6 March 2014

RE: PROC-1000395 – WEST CULBURRA WATER CYCLE MANAGEMENT REVIEW

From an assessment of the Martens consulting engineers report "Water Cycle Management Report – Mixed Use Subdivision; West Culburra, NSW – P1203365JR01V04" dated October 2013, we have identified a number of issues that would require further work.

25405-37

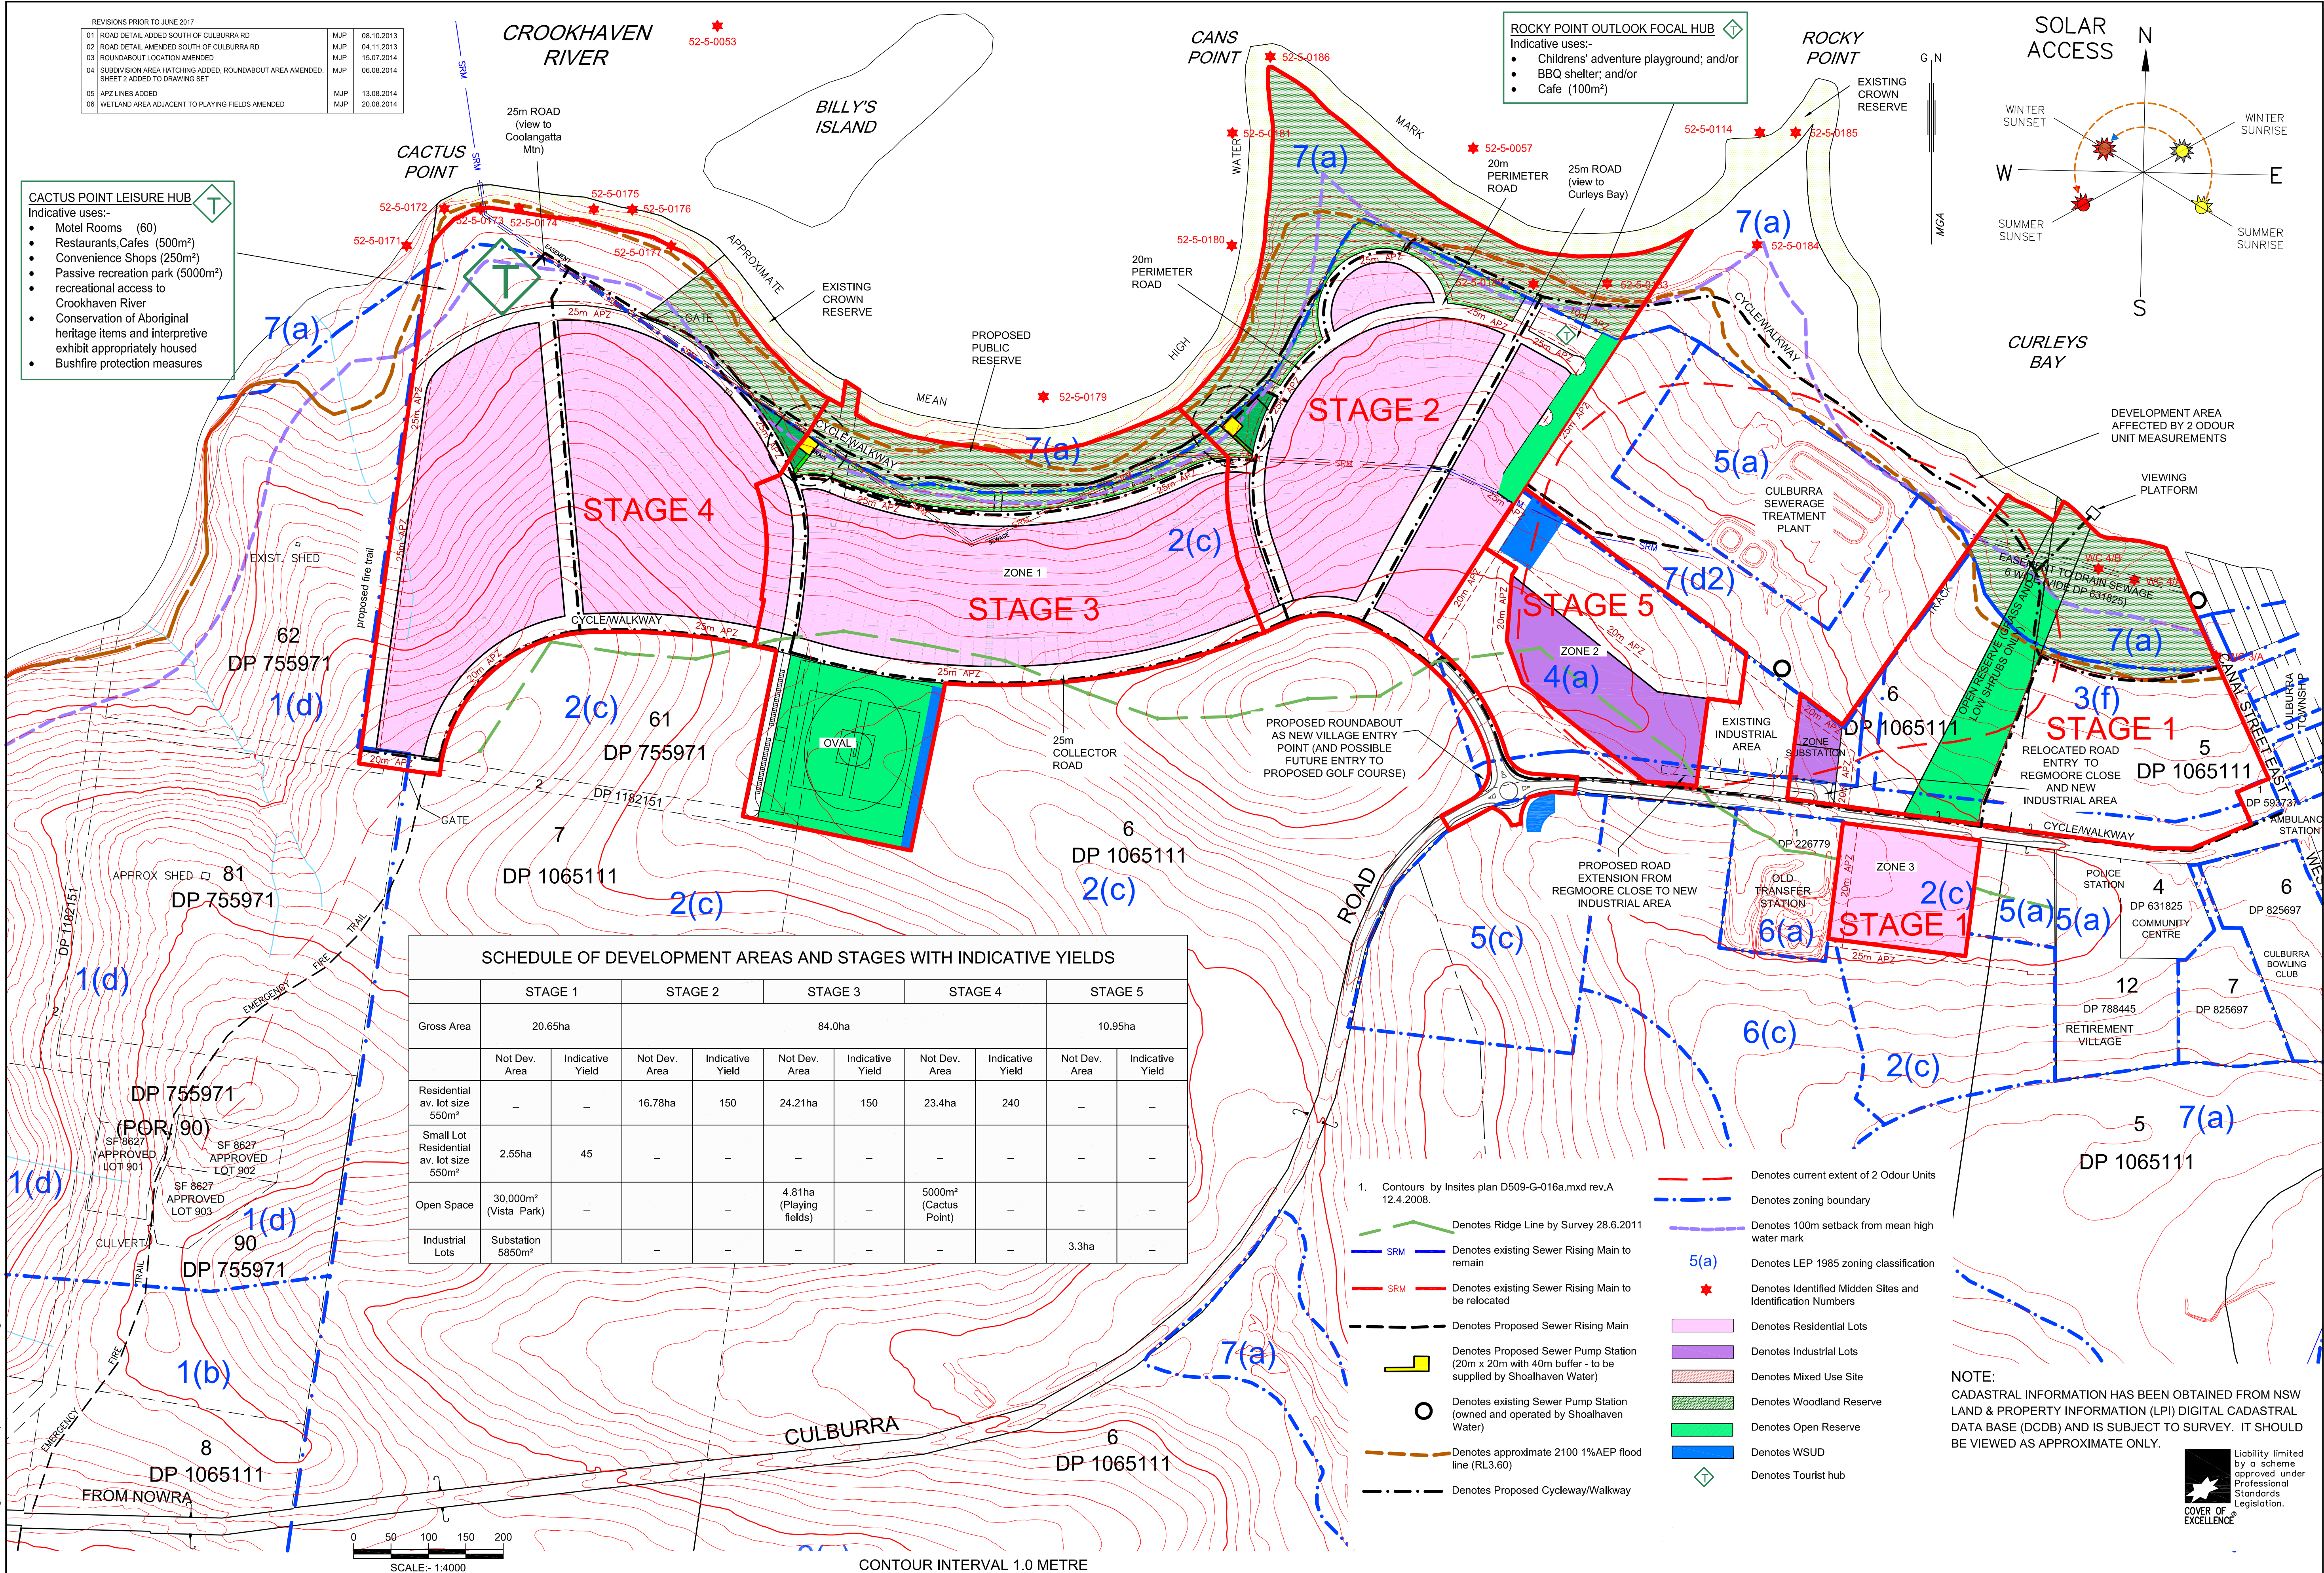
Whilst development controls such as the FPL are typically based on the 1% AEP flood condition, larger flood events up to the Probable Maximum Flood (PMF) are considered in relation to flood emergency risk management and response. The ground level contours shown on Drawing 25405-37 indicate a relatively steeply rising ground surface away from the typical flood inundation extents. The majority of the area within the development extent lies above the PMF, thereby providing suitable flood refuge above the PMF level with suitable access. Further, the large size of the contributing catchment for the Crookhaven River is expected to provide a reasonable flood warning time to enact suitable flood response.
